SUBJECT: **BRES2205-0021**
BUILDING RESIDENTIAL

Here are the results of all Inspections located at **340 FIELDSTONE DR:**

A WALL SECTION
SCALE: 1"=1'-0"

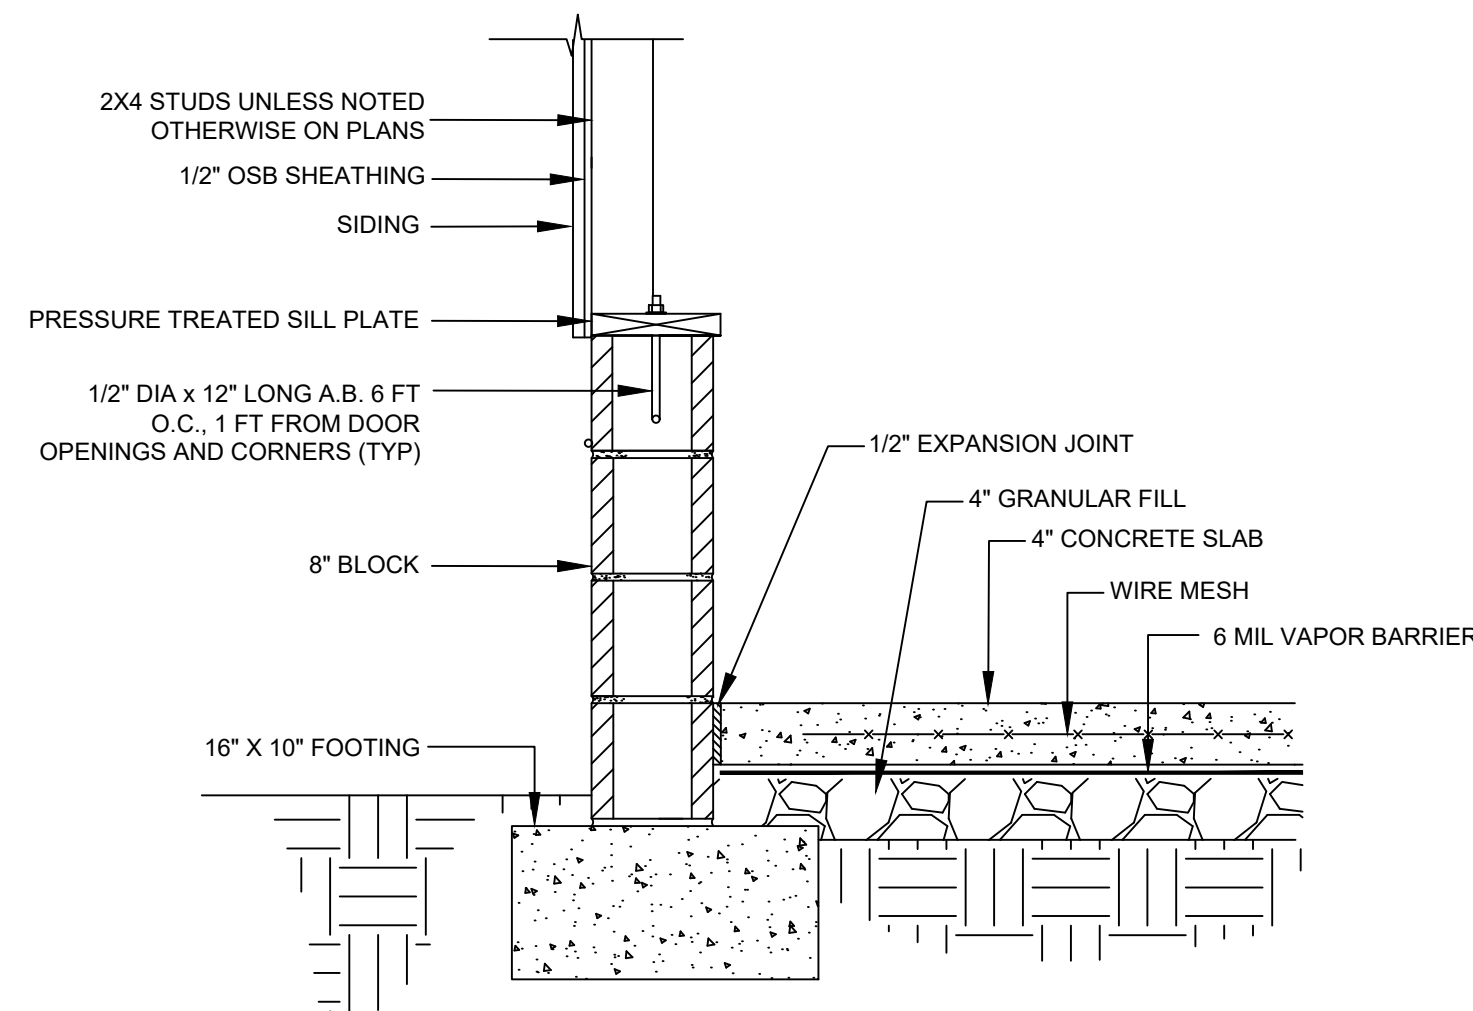
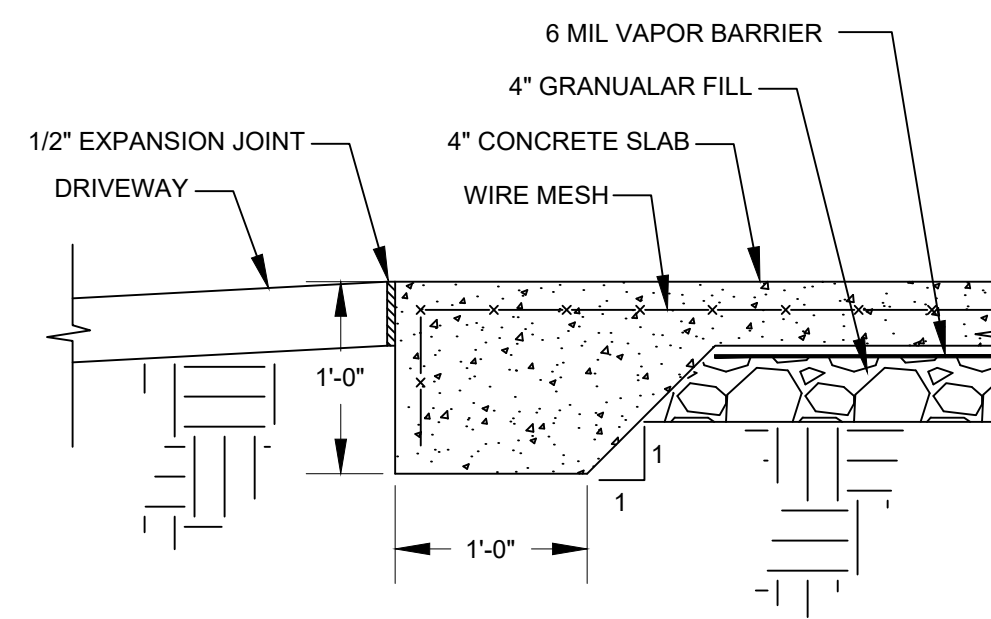
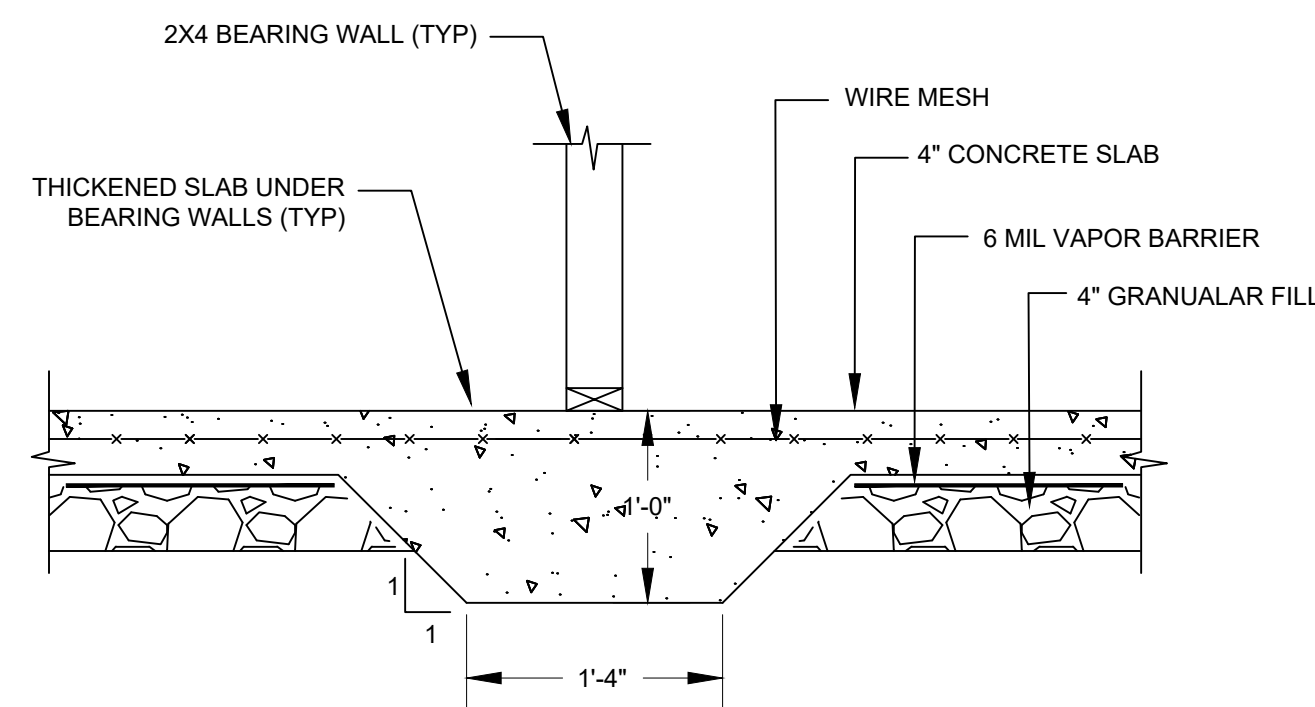
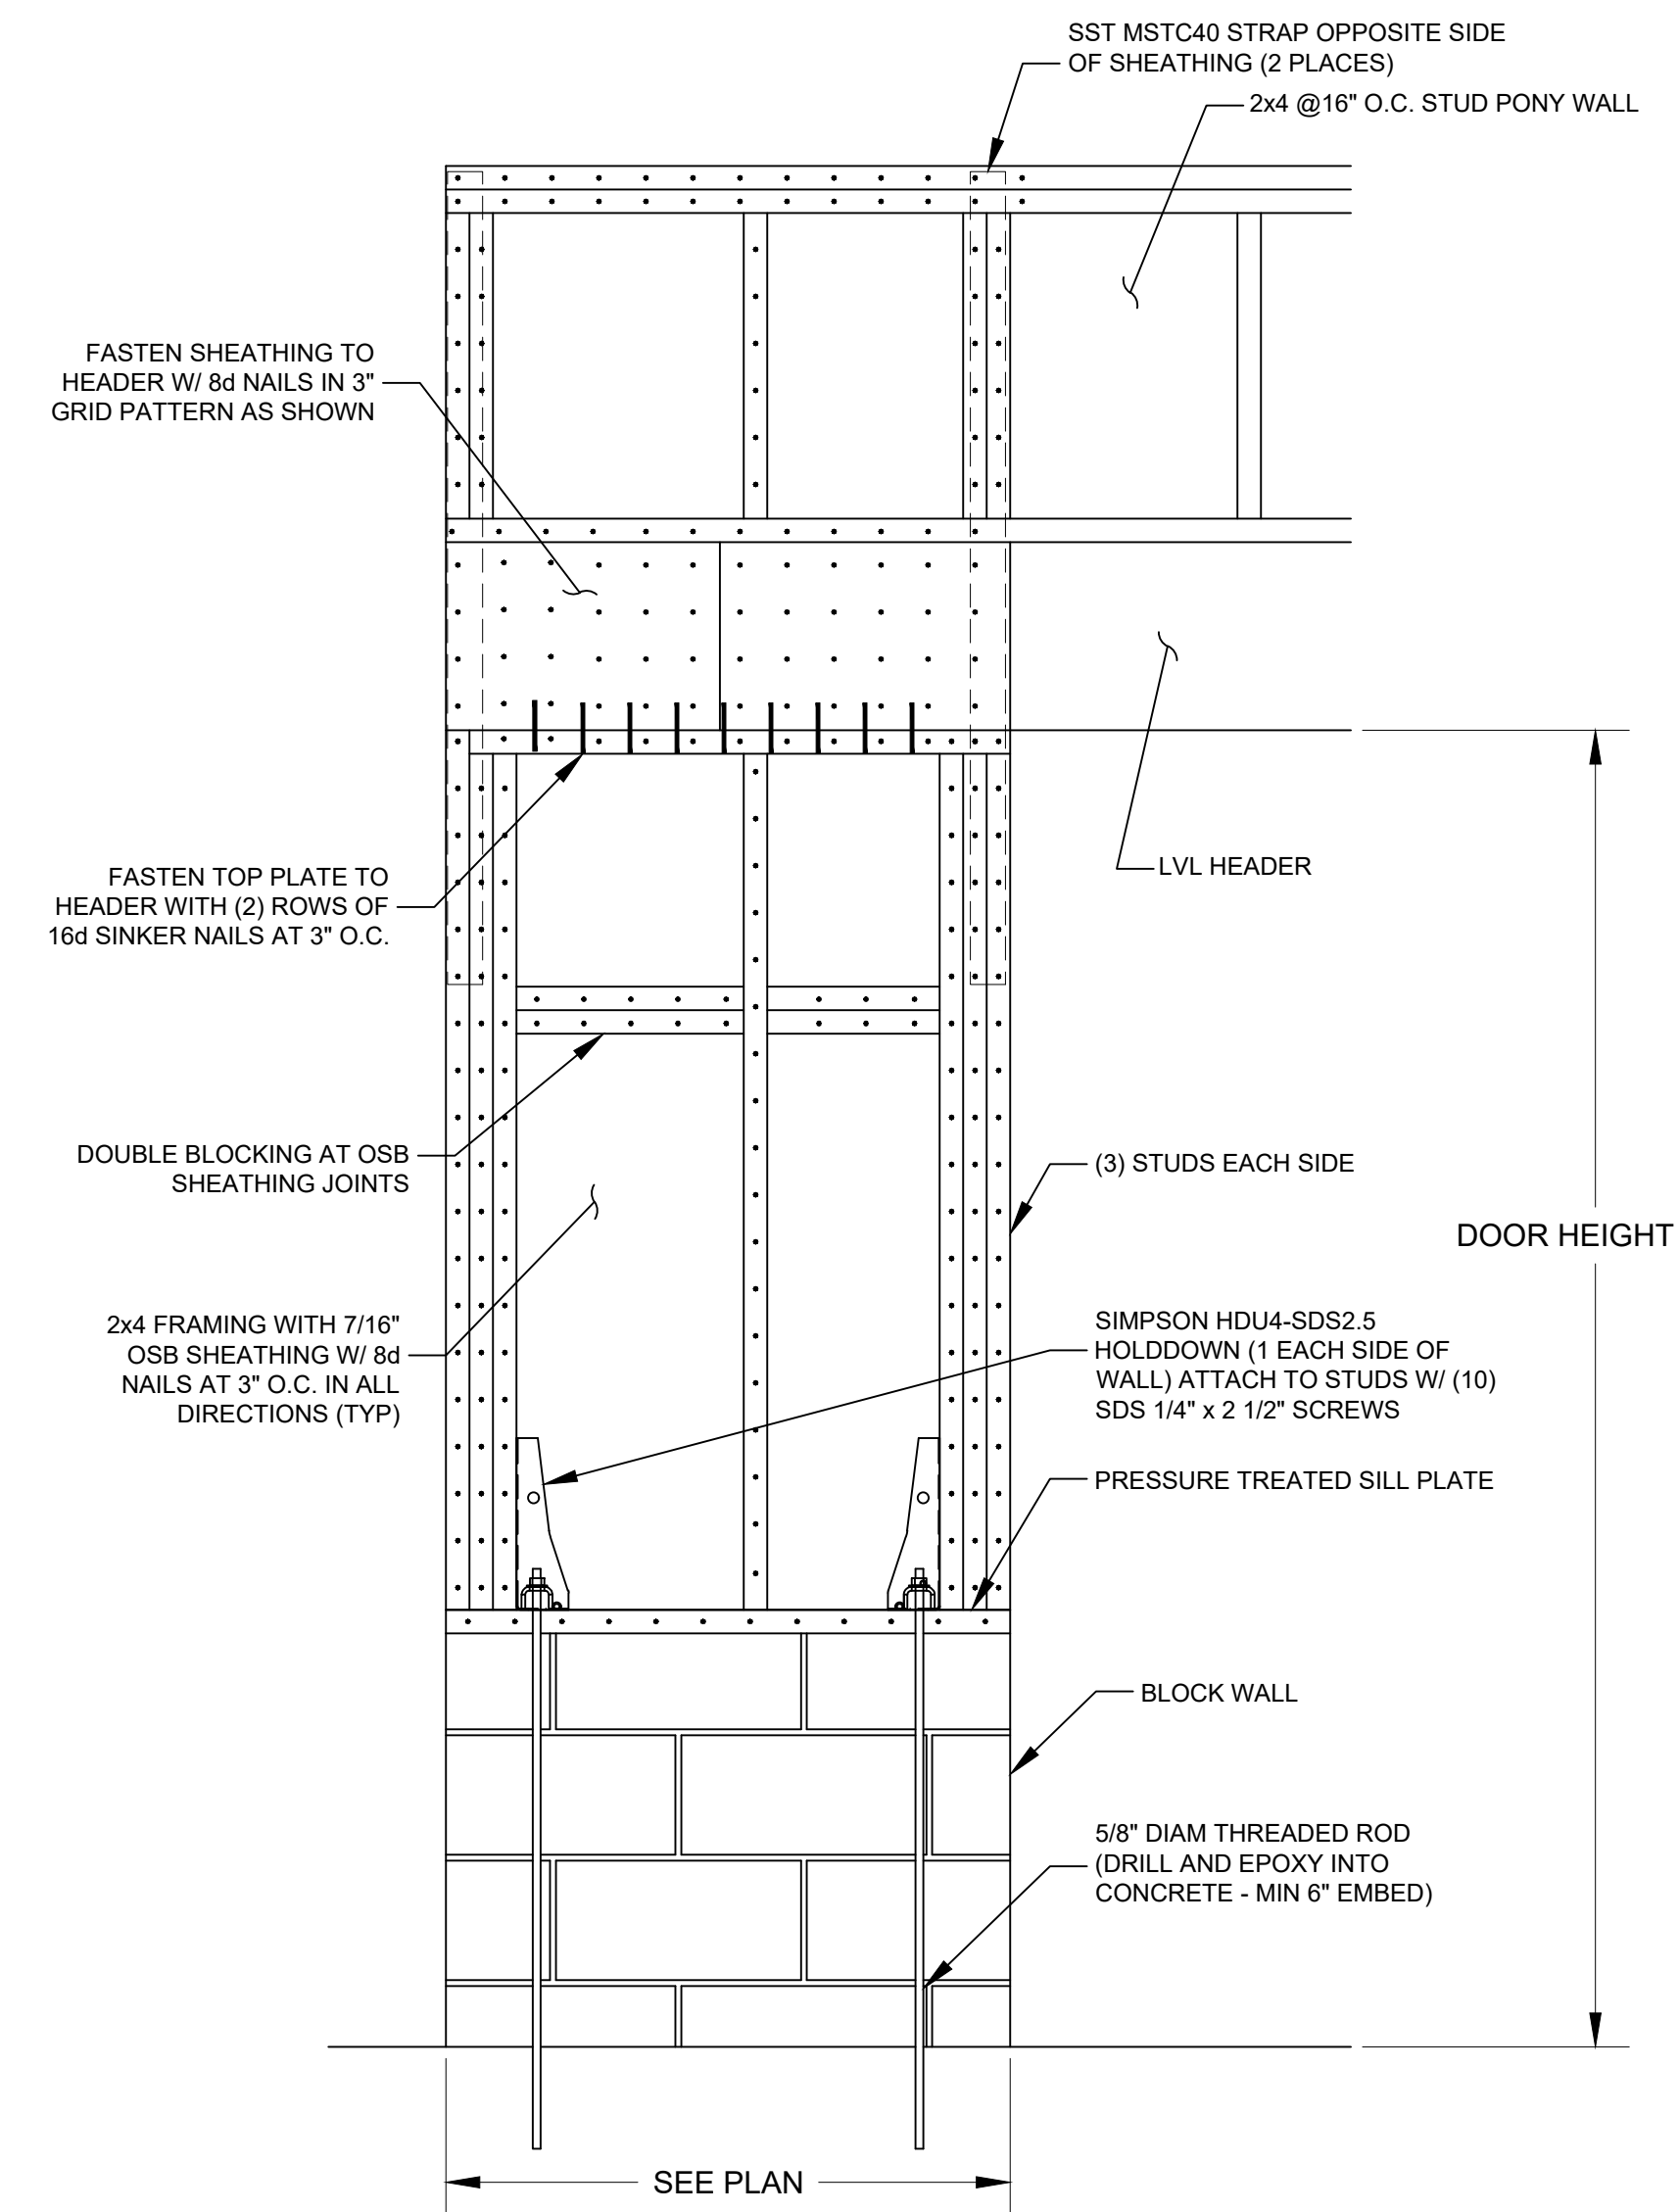
Will need engineer letter for 2x4 wall stud height per code. The plan drawn does show 2x4 for the wall but the plan does not have the engineers seal on it. Ok to cover exterior.

Inspection Type: ROUGH IN REINSPECT
Scheduled Date/Time: 11/7/2022
Completed Date/Time: 11/7/2022
Inspector: Justin Ryan McLeod
Result: APPROVED
Remarks: eTRAKiT Inspection Request
Notes: 11/2/2022 3:50 PM Robert Clade
engineer letter emailed to central permitting
Contact Name: Robert Clade
Site Address: 340 FIELDSTONE DR
Phone: 9193691507
e-Mail: bob@garagebuildersofraleigh.com
